Craigweil House and its Environs

AW-267-15 - HH – Objection to roof change and cladding proposals – 15-10-15

**OBJECTION to AW/267/15/HH - replacement of clay tile roof and proposed
cladding and cladding colour – 68 The Drive – within the
Craigweil House Conservation Area and Craigweil House Area of Special Character**

BLOCK PLAN 1:500

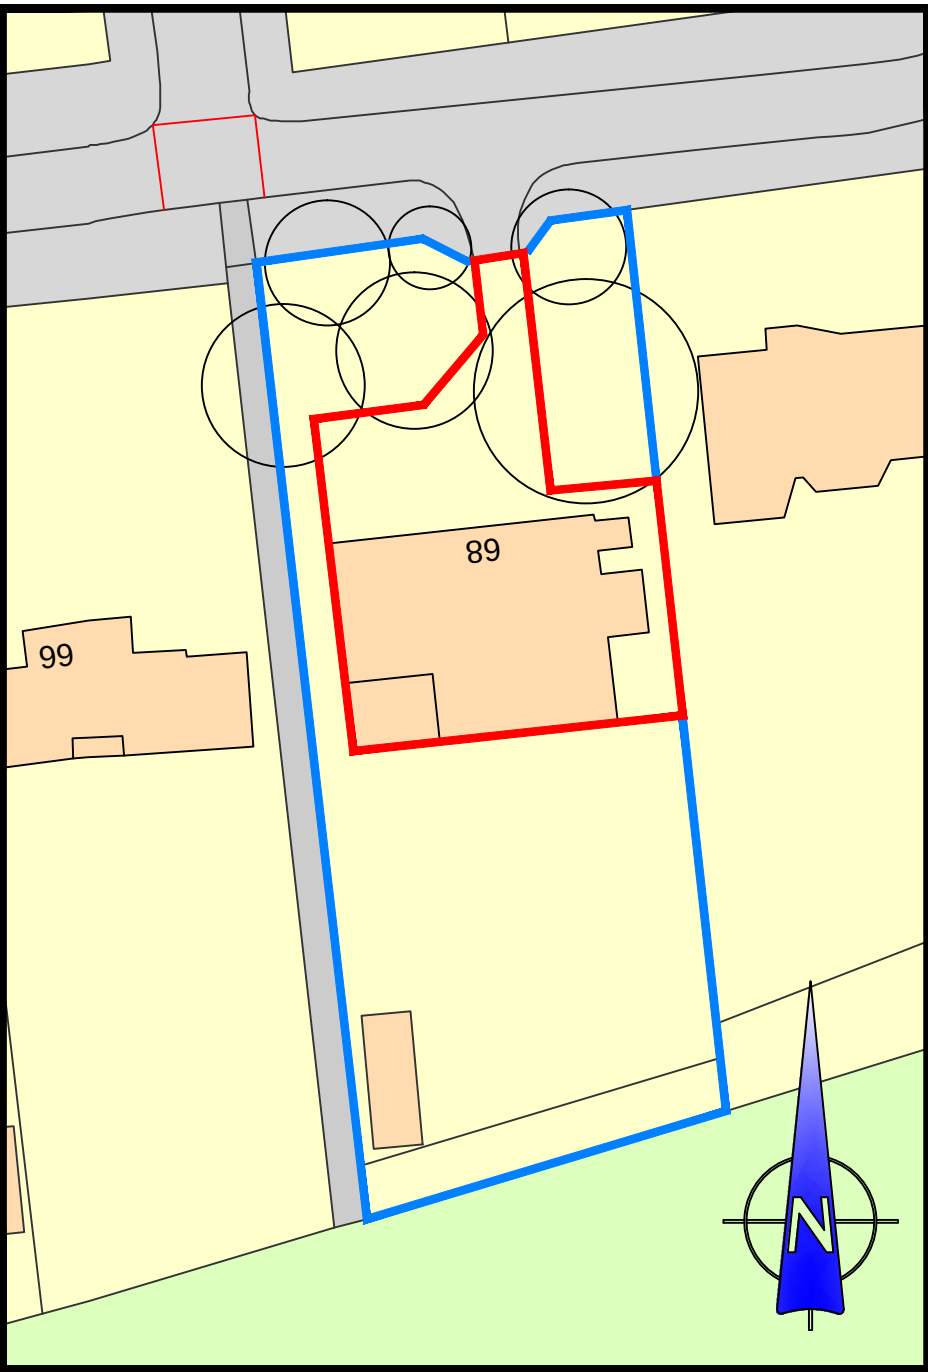
In the application form, at 7, it is falsely stated that no trees are within falling distance of the house. Two Oak Trees certainly are. On the Boundary and Block plans it is falsely indicated that massive areas, now part of the development, are not associated with it. **We say that the applicant should be made to respect and observe those boundaries and not to breach them – and that includes moving two massive containers at the front.**

PROPOSED FIRST FLOOR PLAN 1:100

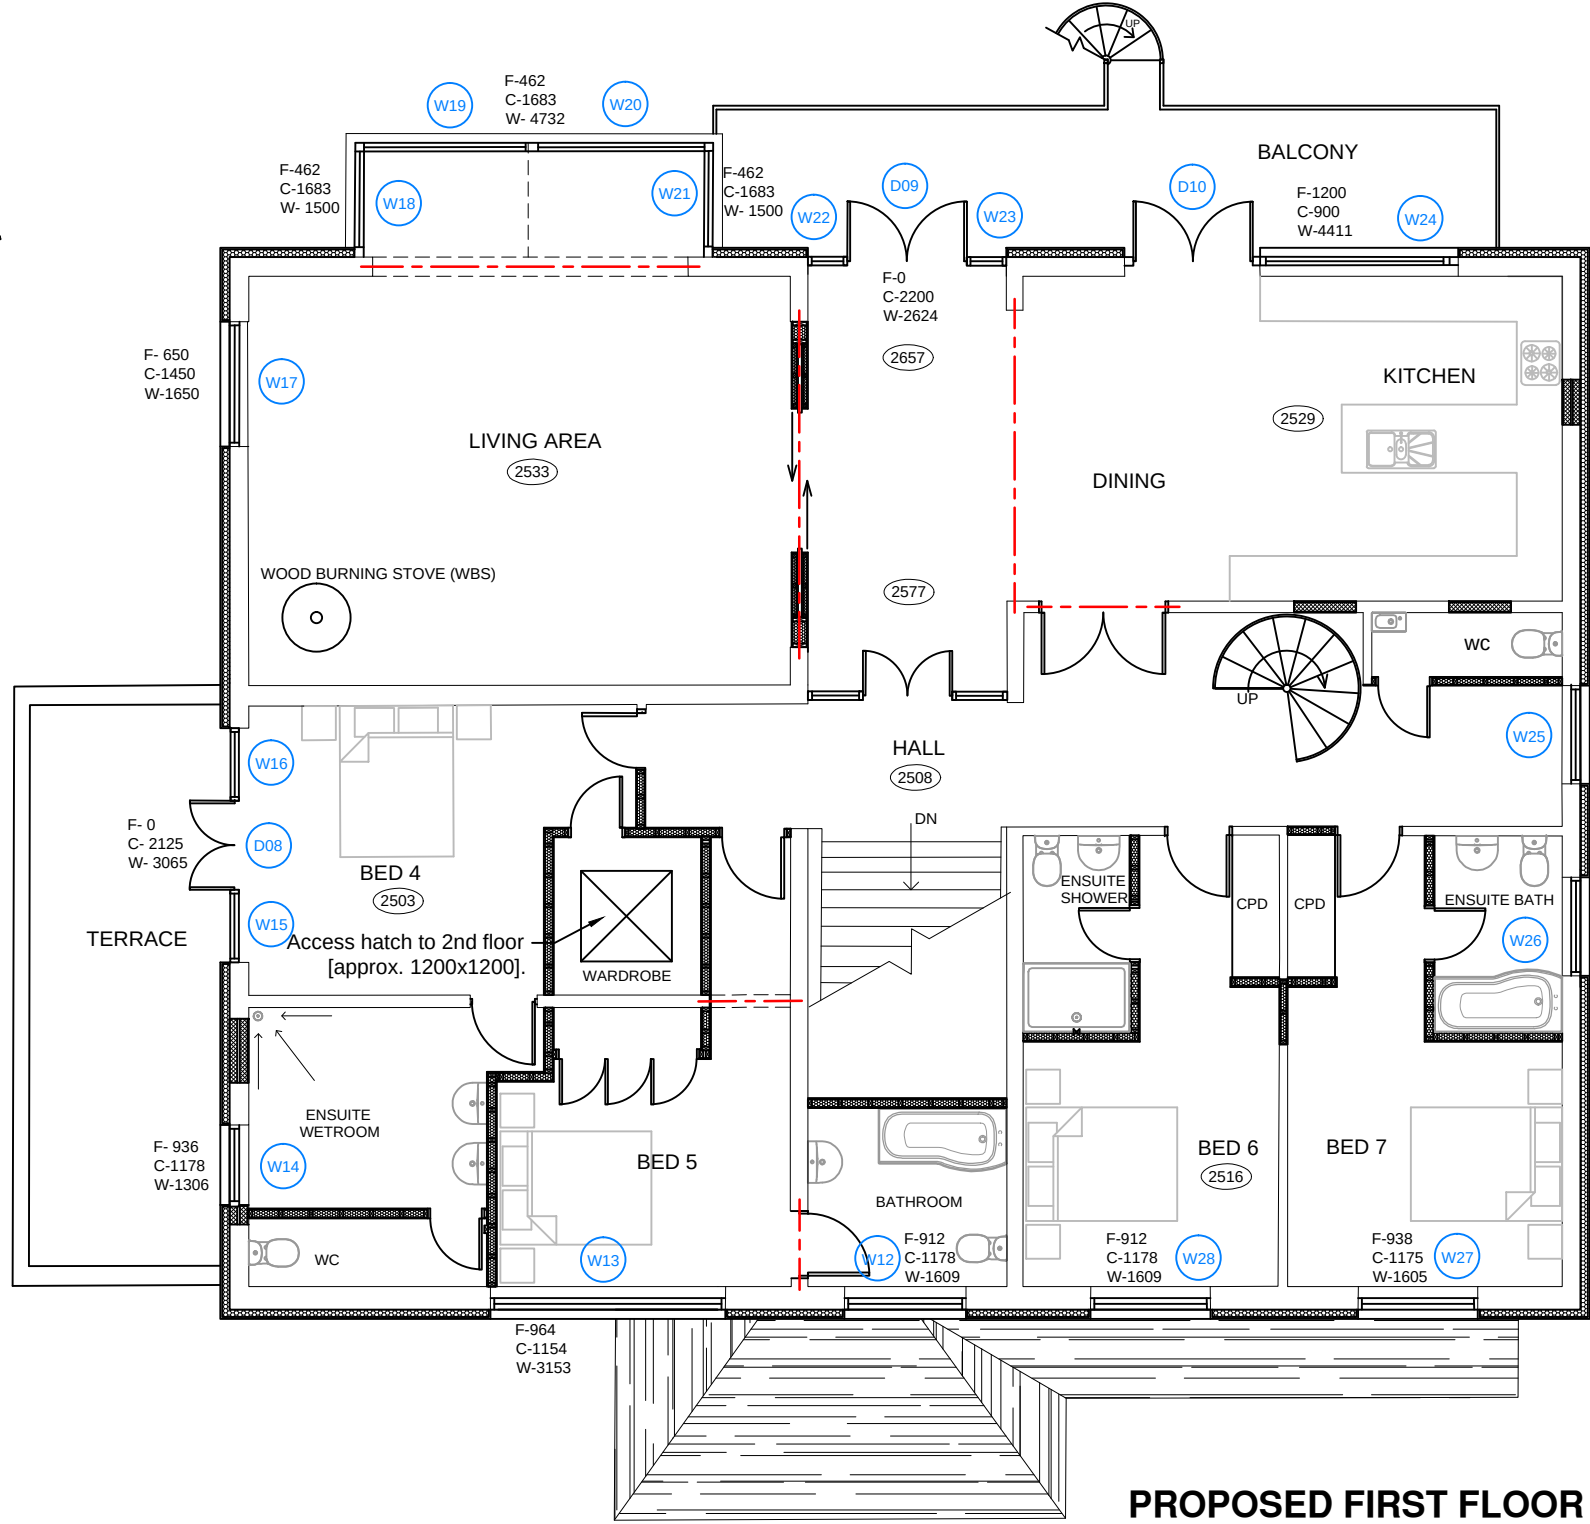
And that part of GEN7 applies equally to the proposed substantial balcony to be created at first floor level on the eastern side of the house in addition to the balcony which runs virtually the whole length to the south (rear) side, facing the sea and with a metal spiral staircase integral with it.

CHECAA says that this is unreasonable and unnecessary for it serves only to enable overlooking to the bungalows to the north of The Drive and into the front and rear garden of No. 70 The Drive. There is debate as to whether or not glass screening with a stainless steel framework should be allowed or a blockwork enclosure. CHECAA are indifferent to the form of enclosure but maintain that the balcony should not be allowed. There is NO precedent for a side balcony on ANY house within the CA and to allow this would create a harmful impact and precedent. This proposal shows a complete disregard for the provisions of Policy GEN19 in relation to overlooking and overbearing effect on neighbouring properties. It shows no respect or consideration for the applicant’s established, elderly and sick neighbours and we consider that it should not be permitted.
